Our Case Number: ABP-314724-22

Re: Railway (Metrolink - Estuary to Charlemont via Dublin Airport) Order [2022]
Metrolink. Estuary through Swords, Dublin Airport, Ballymun, Glasnevin and City Centre to Charlemont, Co. Dublin

**Re : Railway (Metrolink–Estuary to Charlemont via Dublin Airport) Order 2022
4 Earlsfort Terrace Dublin 2 (Formerly known as Dolman House)**

This submission has been prepared by Waterman Moylan on behalf of Irish Life Assurance plc. who are the owners of the existing commercial building located at 4 Earlsfort Terrace Dublin 2 (Formerly known as Dolman House)

### Figure 14.2 Groundborne Noise from Tunnel Boring Machine Sheet 7 of 7

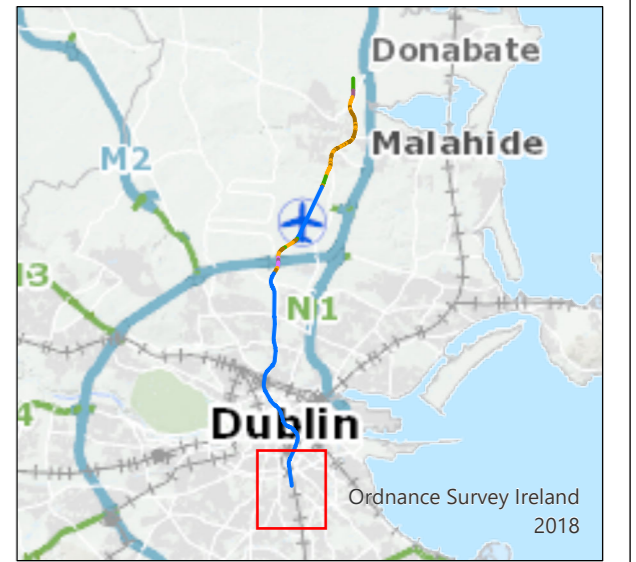
- a) Metrolink has assessed the "*Groundborne Noise from Tunnel Boring Machine*" and presents its findings on drawing no. ML1-JAI-EIA-ROUT-XX-DR-Y-14009 (a copy is attached to this submission). This drawing indicates MetroLink will generate an additional 45db directly under the location of our client's building which is unacceptable.

Drawing Title
Figure 14.6 Groundborne Noise from Operation
 Sheet 7 of 7

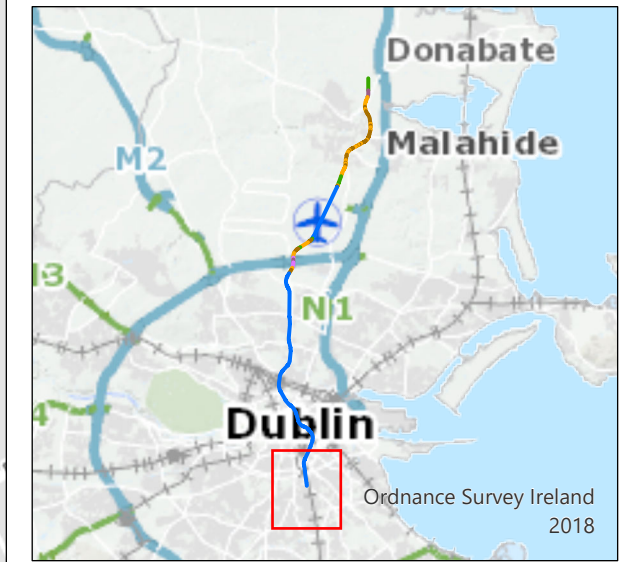
- a) Metrolink has assessed the "*Groundborne Noise from Operation*" and presented its findings on drawing no. ML1-JAI-EIA-ROUT-XX-DR-Y-14041 (a copy is attached to this submission). This drawing indicates MetroLink will be generating an additional 25db directly under the location of our Clients building which is unacceptable.
